Your ref: SSI-10040  
Our ref: DOC20/884122-8

**Notice of Exhibition of application for Project EnergyConnect (NSW – Western Section) (SSI-10040)**

Enclosure – Attachment A: Detailed comments on Project EnergyConnect (NSW – Western Section) (SSI-10040)  
- Aboriginal Cultural Heritage

DISCOVERY OF SUSPECTED HUMAN REMAINS PROCEDURE

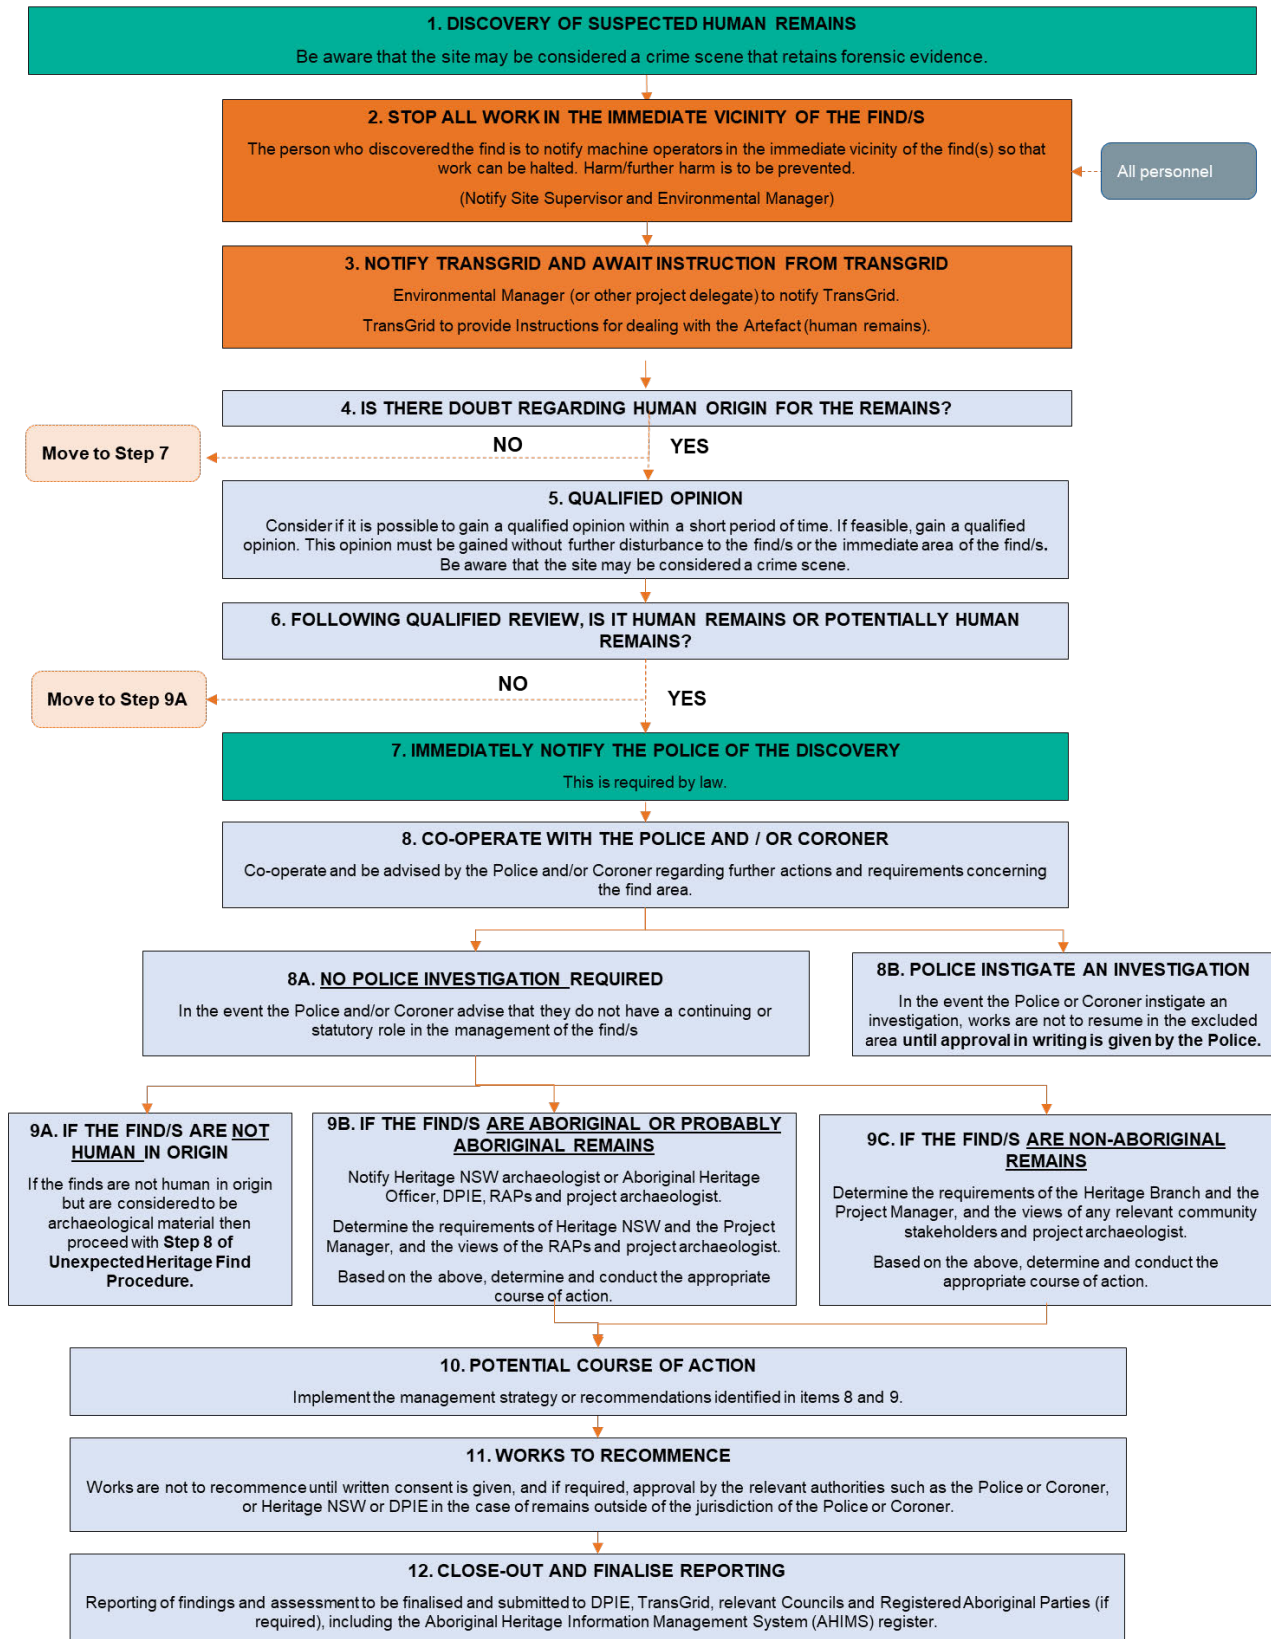
- the protocol for the discovery of human remains is generally adequate. Point 3 of the process needs to be amended to contacting only the NSW Police in the first instance. If it is a missing person, it can be inappropriate to have unassociated stakeholders involved. Under the *Coroners Act 2009*, until it is determined exactly what is being dealt with, the NSW Police are the lead agency and make decisions around who should be notified and who is appropriate to have involved.

**Heritage NSW advises the protocol for the discovery of human remains is generally adequate.**

Point 3 of the process needs to be amended to contacting only the NSW Police in the first instance. If it is a missing person, it can be inappropriate to have unassociated stakeholders involved. Under the *Coroners Act 2009*, until it is determined exactly what is being dealt with, the NSW Police are the lead agency and make decisions around who should be notified and who is appropriate to have involved.
